SUBJECT: Esteban Rodriguez Subdivision Sketch Plan
RE: Traffic Impact Study
Response to Wilson Comments
LSC #S224630

Following are the LSC Transportation Consultants, Inc. responses to the Nov 21, 2023 Comment email by Max Rusch regarding comments on the Esteban Rodriguez Subdivision Sketch Plan.

Figure 3
 Existing Traffic, Lane
 Geometry, Traffic
 Control, and LOS

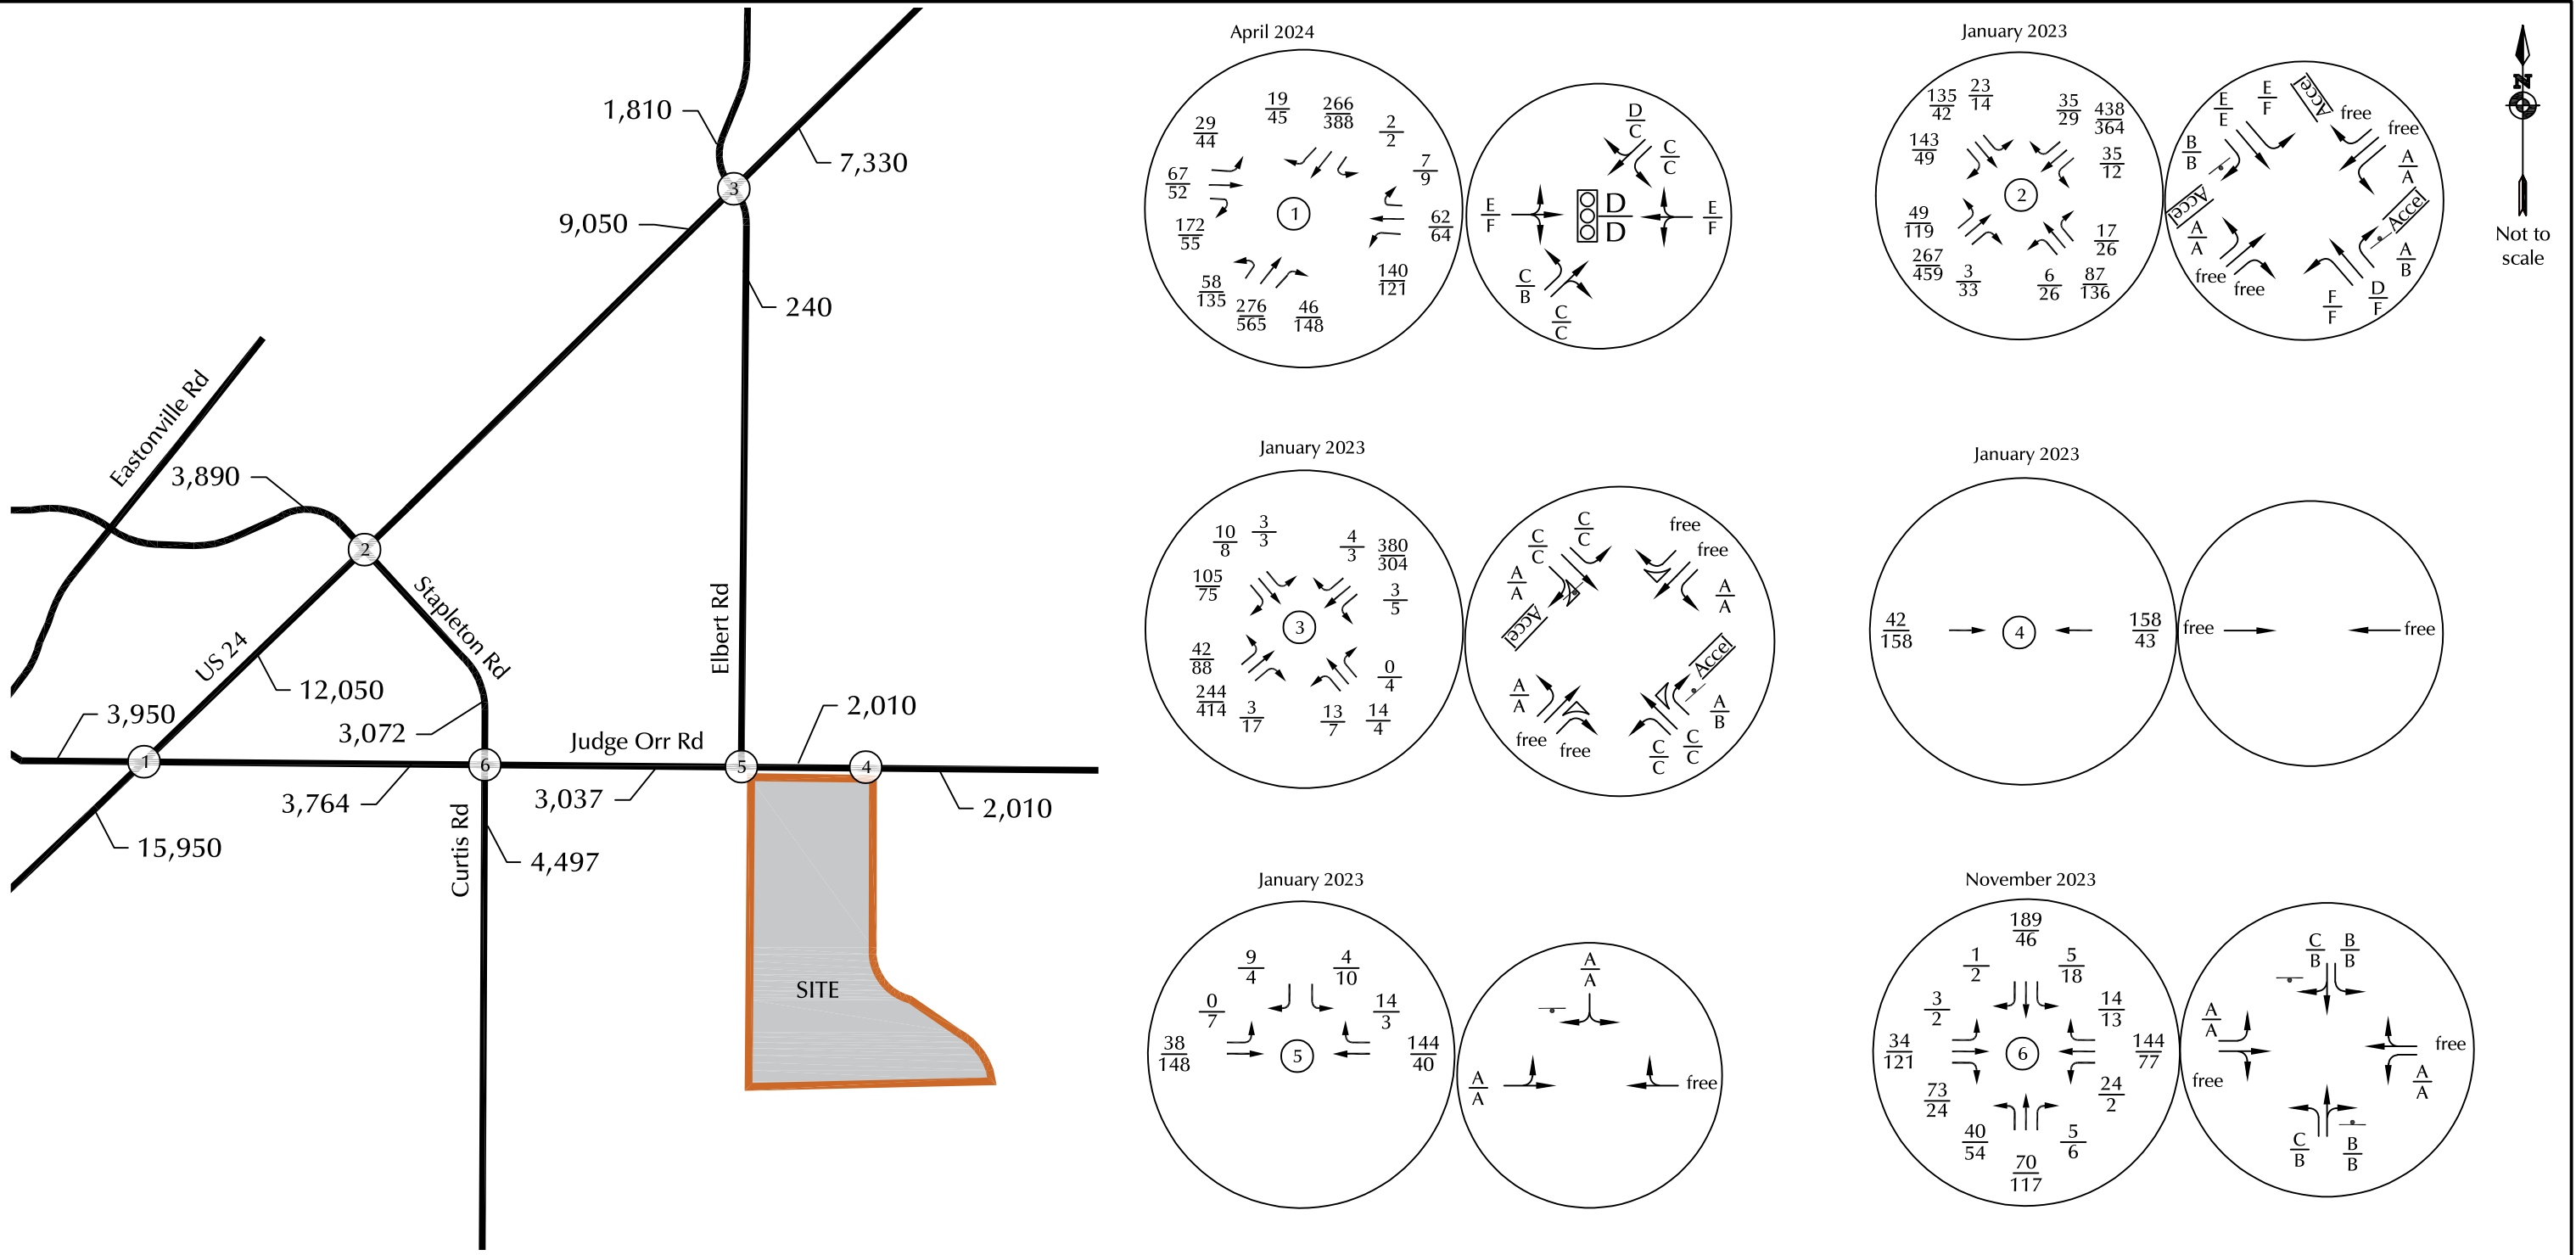
1. *Per ECM B.2.2., an existing conditions scenario is required in the study.*

LSC Response: An “existing” scenario has been added to the report, including figures with counts and LOS.
